Recommendation Report for Planning Permission for Works or Extension to a Dwelling

REF NO: AW/41/25/HH

LOCATION: 12 Aldbourne Drive
Aldwick
PO21 4NE

PROPOSAL: Proposed single storey rear extension and alterations. This application may affect the character and appearance of a Craigwell House Conservation Area.

Proposed Elevations

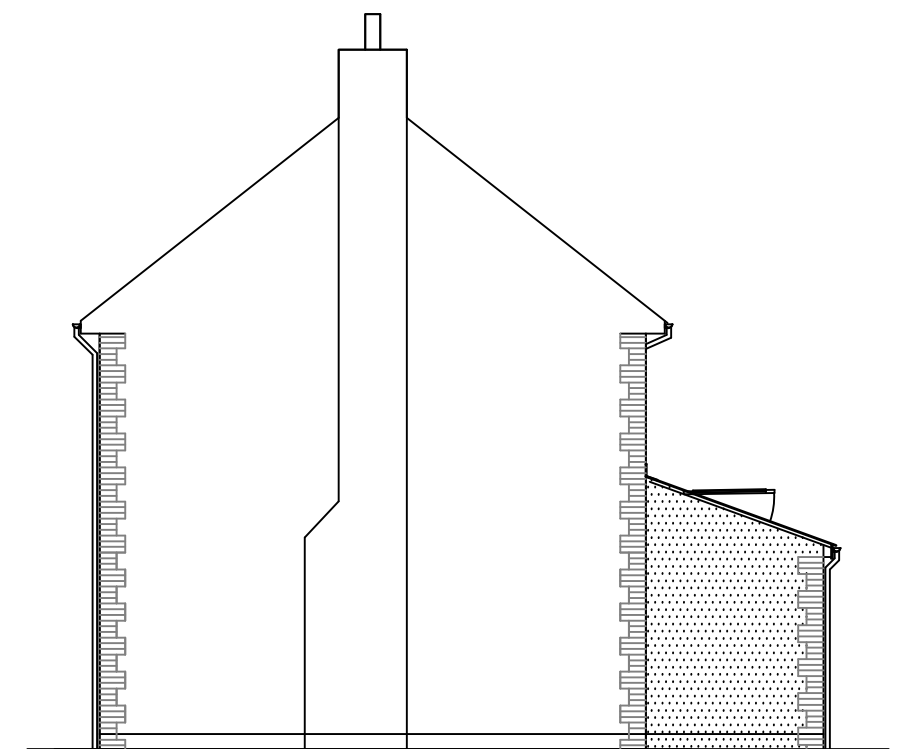
The site is a two storey detached dwelling on the corner of Aldbourne Drive. The proposal is for a single storey rear extension and the proposal would not be visible from the public realm. The rear extension would have a depth of 2.4m and it would extend across the rear elevation of the host dwelling. The extension has a lean-to pitched roof, with a maximum height of 3.7m. The extension would remain subservient to the existing dwelling, and is acceptable in terms of its scale and massing in accordance with policy D DM4 of the Arun Local Plan. The proposed materials are brickwork and concrete tiles to

match the existing dwelling, which would help the addition to integrate in accordance with policy D DM1 of the Arun Local Plan.

The proposal would include fenestration within the rear elevation of the extension. The proposed fenestration would have an outlook of the rear amenity space serving the application site, and the proposed extension would not result in any overlooking.

Proposed Plans

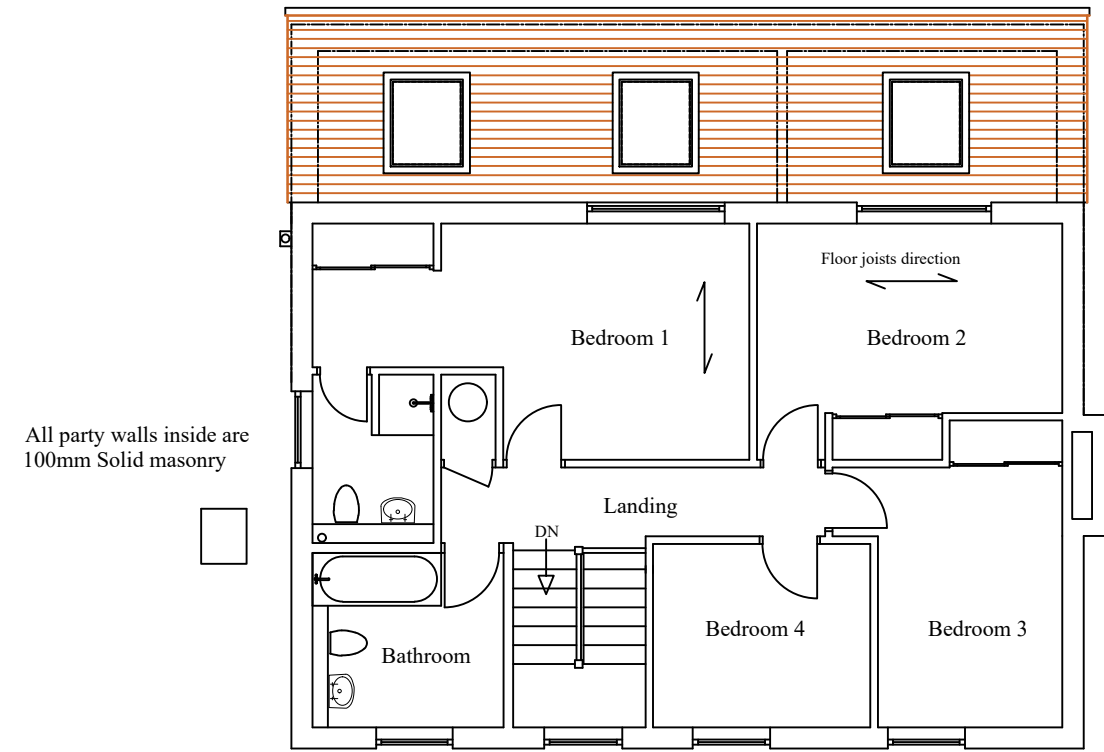
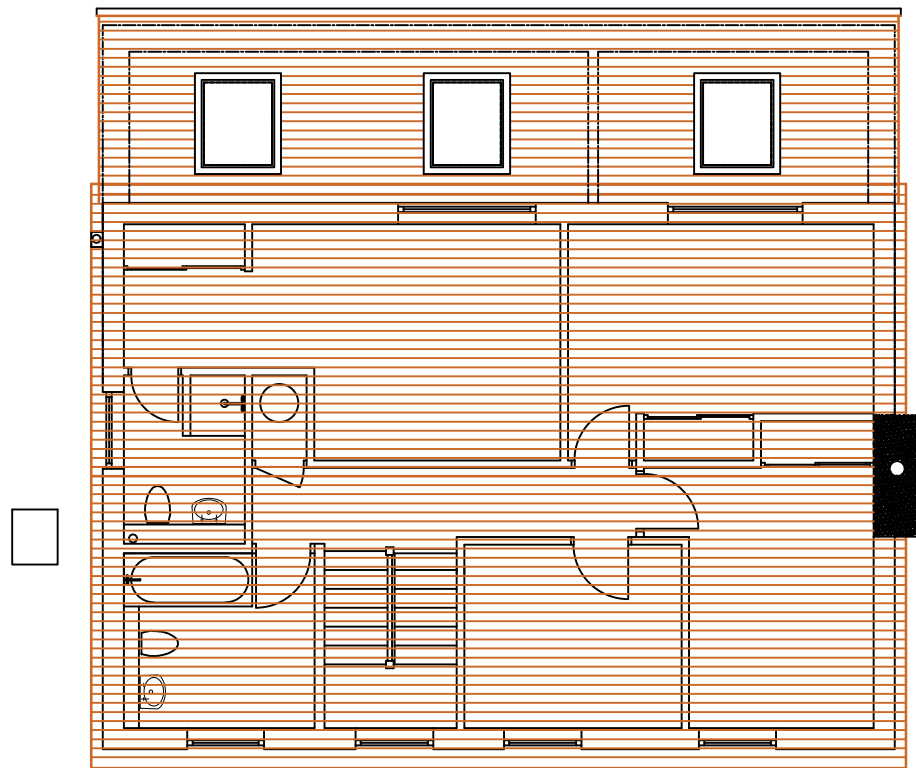
The proposed extension is modest in depth and it would be set in a minimum of 1m from the side boundaries of the application site. There are existing outbuildings adjacent to the boundary with the property to the east, and as such, the proposed rear extension would not result in any harm to this neighbour. The rear extension will extend a short distance beyond the rear elevation of the outbuilding of the neighbour to the west, however, there remains a separation distance of 1m to the boundary and the neighbour to the west is significantly set in from the shared boundary with the application site. Therefore, the proposed rear extension would not result in any harm to neighbouring amenity by way of overbearing or overshadowing impacts.
